Recommendation Report for Planning Permission for Works or Extension to a Dwelling

REF NO: AL/103/12/

LOCATION: 2 New Cottages
Lidsey Road
Bognor Regis

PROPOSAL: Rear and side two storey extensions and alterations. Resubmission of AL/102/11

Title
Plans as Proposed

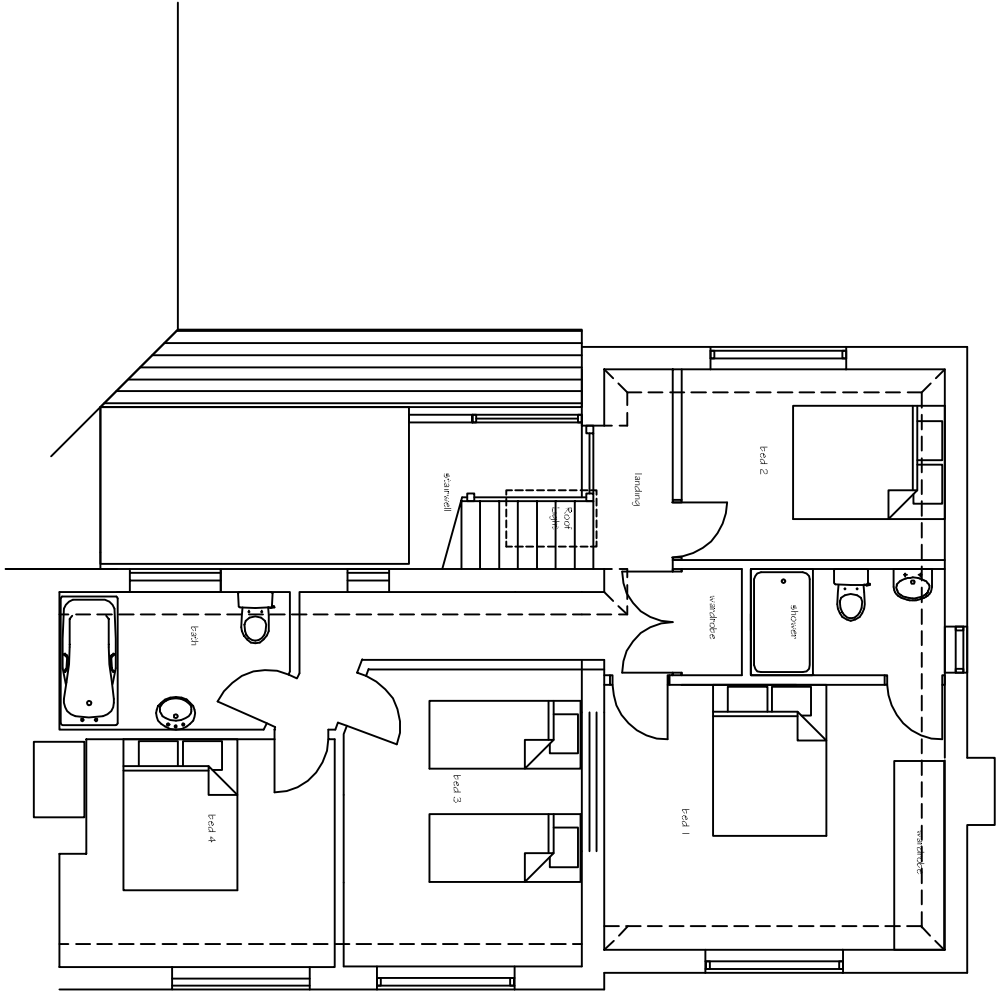
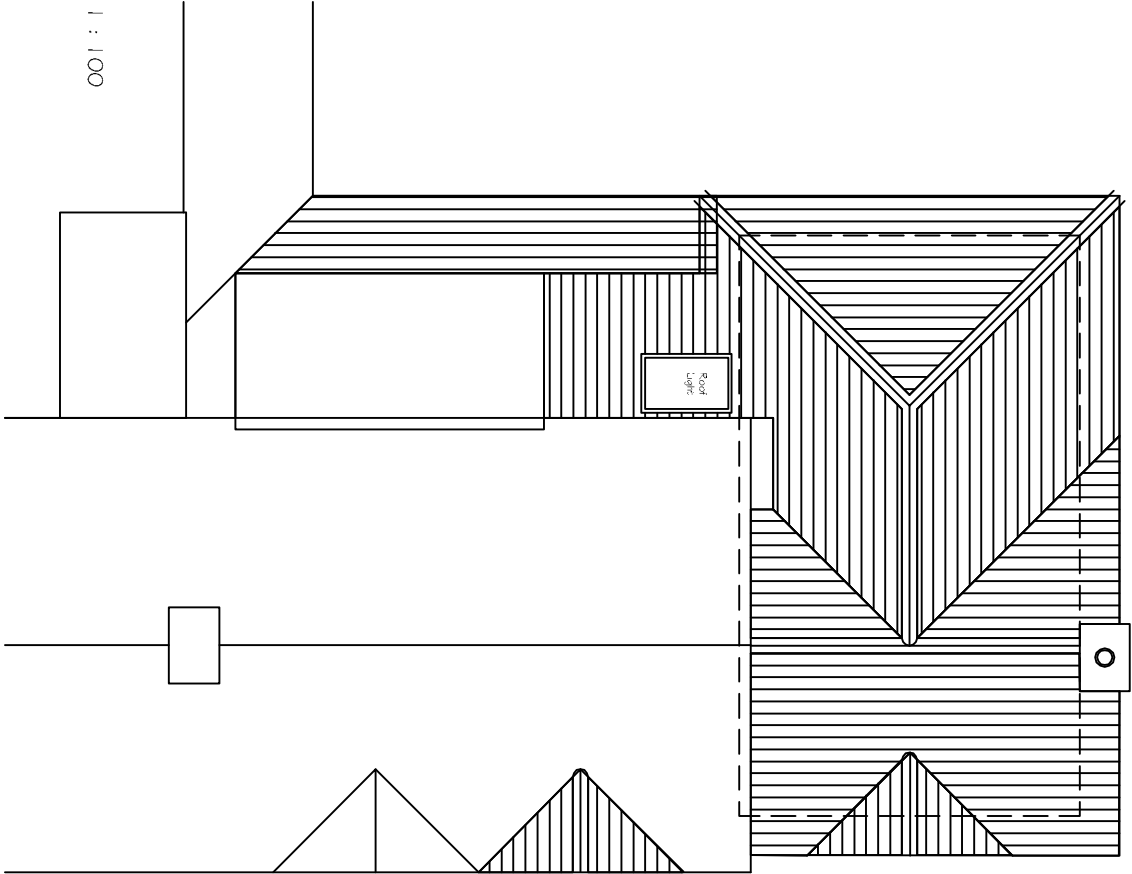
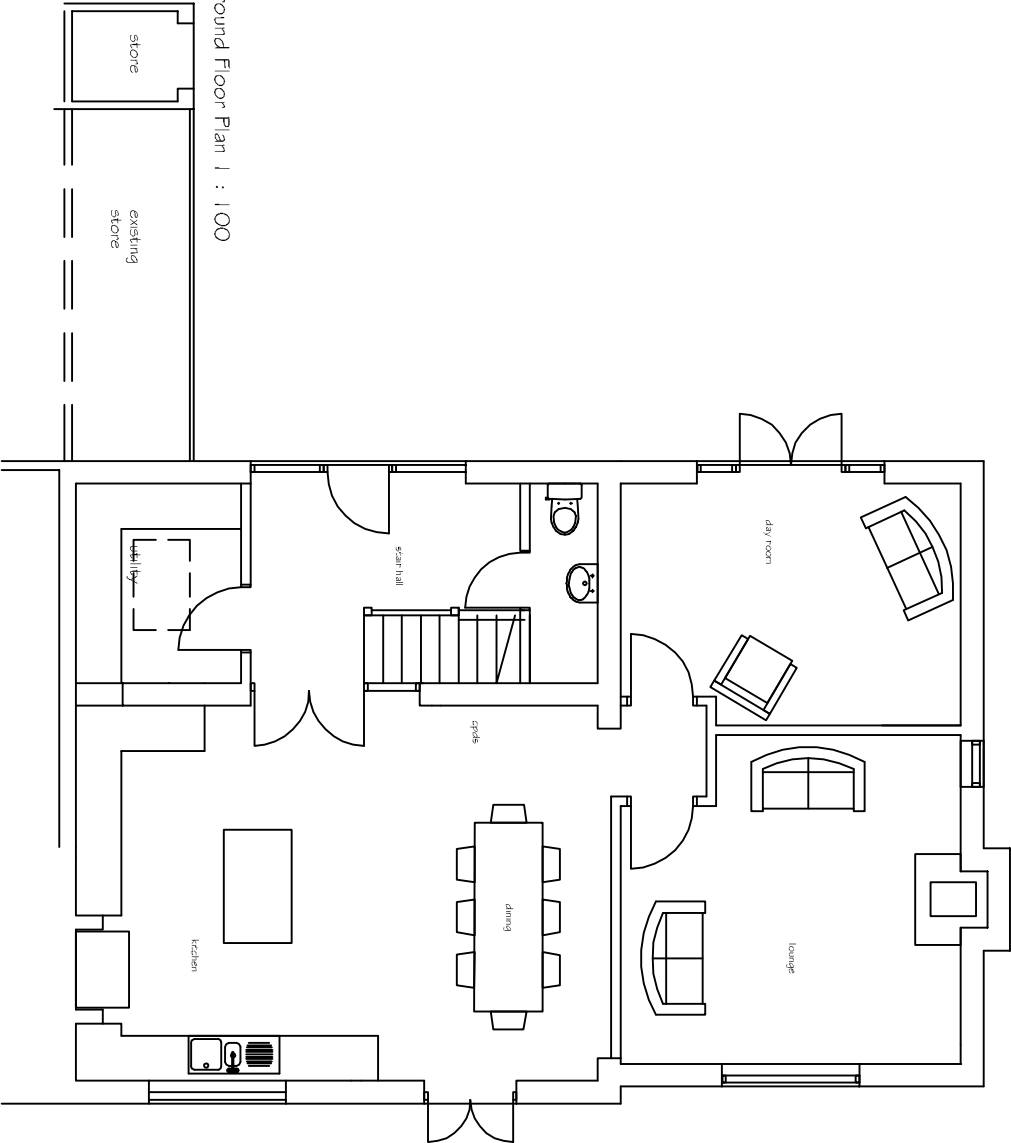
The footprint and height of the proposed two storey side extension is reduced and will be set back from the front elevation, in order to be appear visually subservient when viewed from the road. The roofline of the proposed extension is amended from a hip roof to a pitch roof with gable end, in keeping with the host dwelling, and the design of the rear elevation is simplified by omitting a large rear dormer. The chimney is also increased in height. The proposed elevations would be faced in brick at ground floor level and render at first floor level, with a plain clay tiled roof, to match the host dwelling. Although the proposed extension is large and will have a visual impact from the streetscene along Shripney Road, the design is considered to be sympathetic to the character of the host dwelling and the neighbouring semi-detached property at no. 1 New Cottages.
